Application for Planning Permission for Works or Extension to a Dwelling

Development: Single storey rear extension plus loft conversion including hip to gable and rear dormer.
Location: 8 Sefton Avenue Aldwick PO21 3BP

I regret that I am unable to accept your documents as a valid application until the following item(s) have been received or resolved :-

BLOCK PLAN 1:500 @ A3

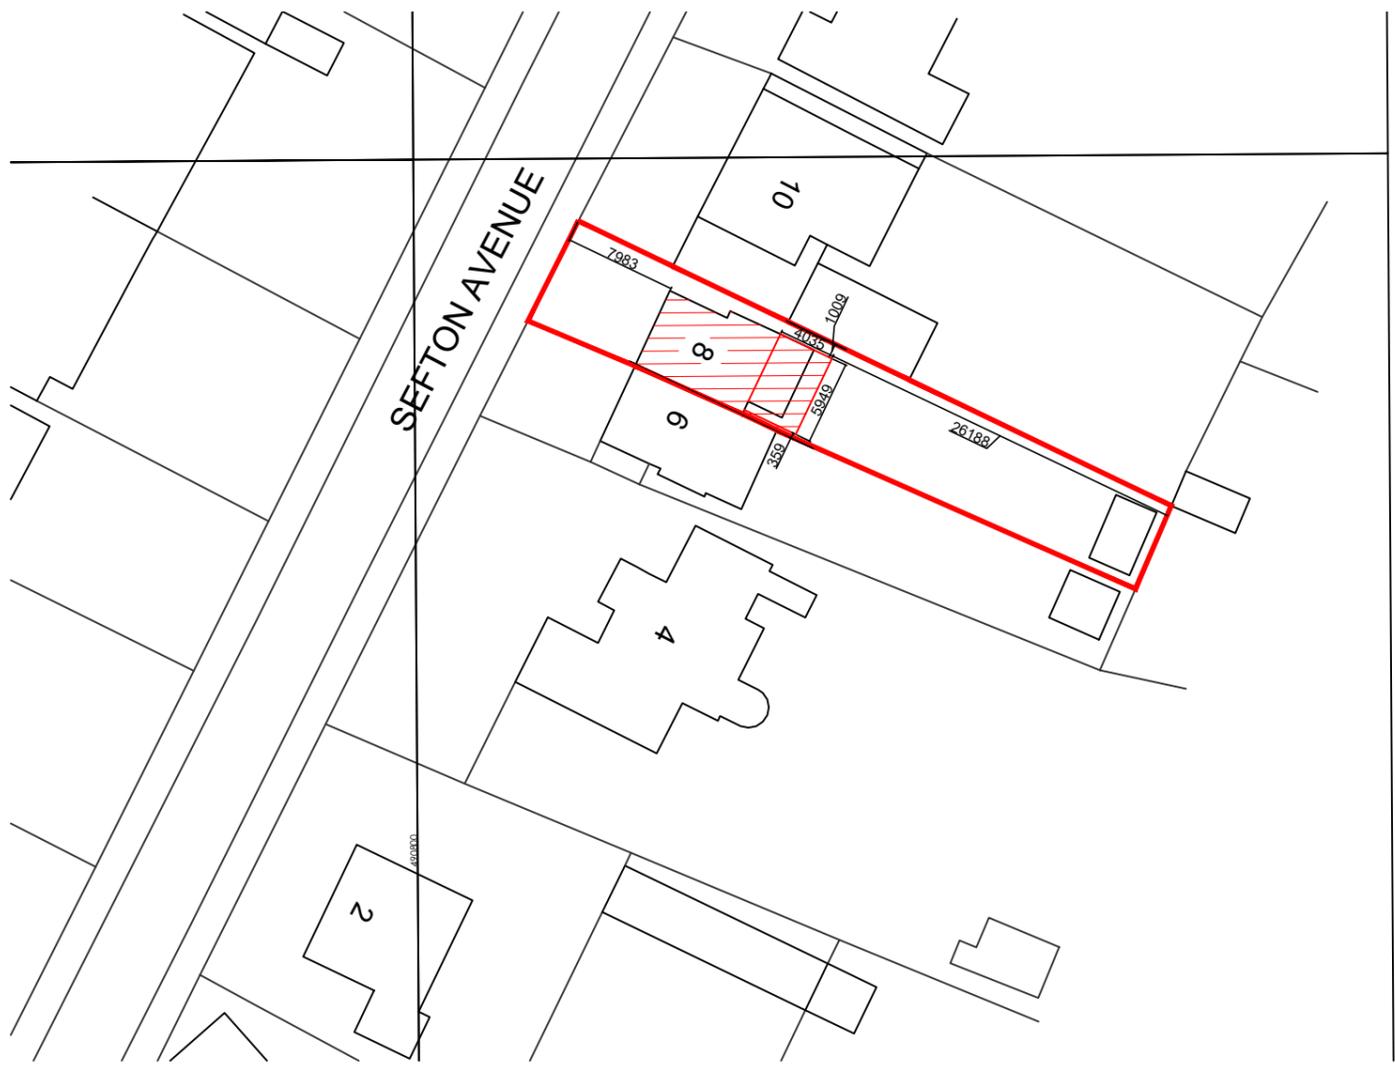
Block Plan

You are required to have dimensions from the proposed extension(s) to all site boundaries. Please amend

LOCATION PLAN 1:1250 @ A3

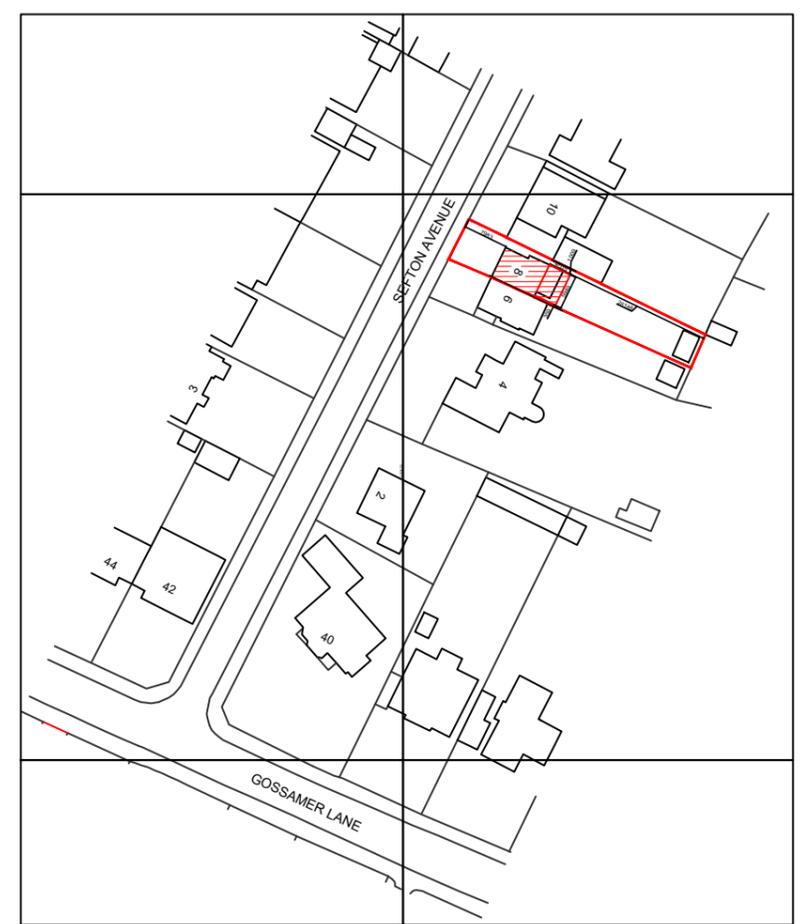
Location Plan Insufficient

The location plan requires a solid red outline around the site boundary, please review and amend. Further details of what must be included on the plan can be found in the Validation Requirements List.
